**Transmittal #:** 39  
**Date:** 5/11/2017  
**Job:** 10-16-1843 Salvation  
Army

**Job:** 10-16-1843  
Salvation Army  
88 Preble Street  
Portland, ME 04101

**Spec Section No:** 230000  
**Submittal No:** 1  
**Revision No:** 0  
**Sent Date:** 5/11/2017

**Submittal Title:** Air Supply, Distribution, Ventilation, Exhaust System

System ID: RTU-1

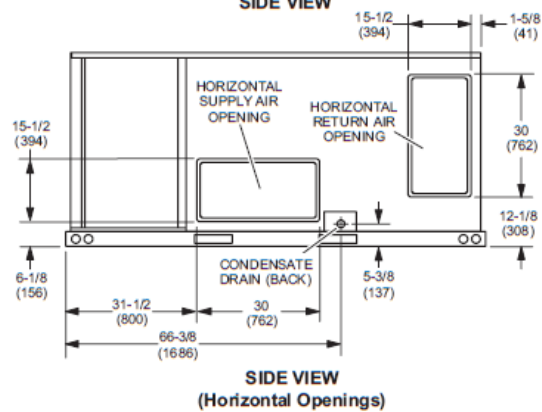
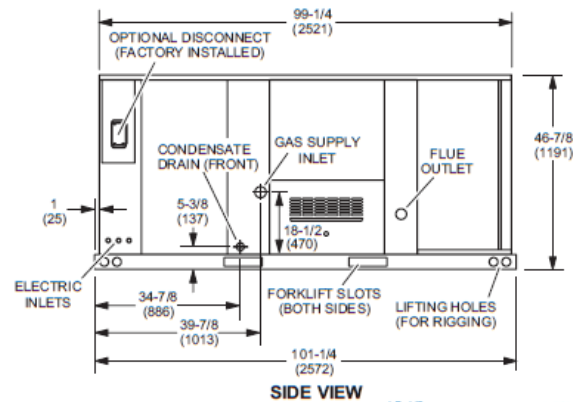
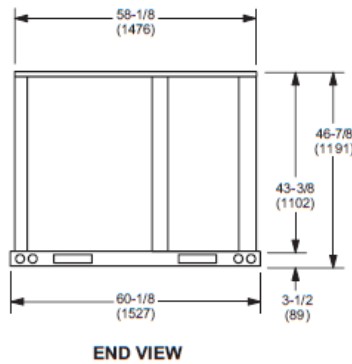
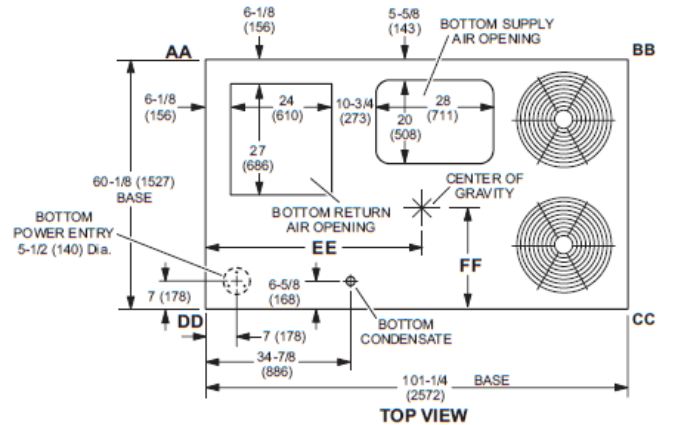
- 2. Resubmit R-1. Needs to match performance of scheduled return grille less than or equal to NC20 at 1875 CFM.
- 3. Confirm maximum outside air flows for RTU-1 and RTU-2 are greater than required ventilation rates on M001. Cutsheets show 800 CFM and 400 CFM, respectively (20%), which is lower than required.
- 4. Ensure RTU-1 and RTU-2 OA intakes are deconflicted from all roof-top exhausts by 10' per Code when selecting orientation of RTUs.
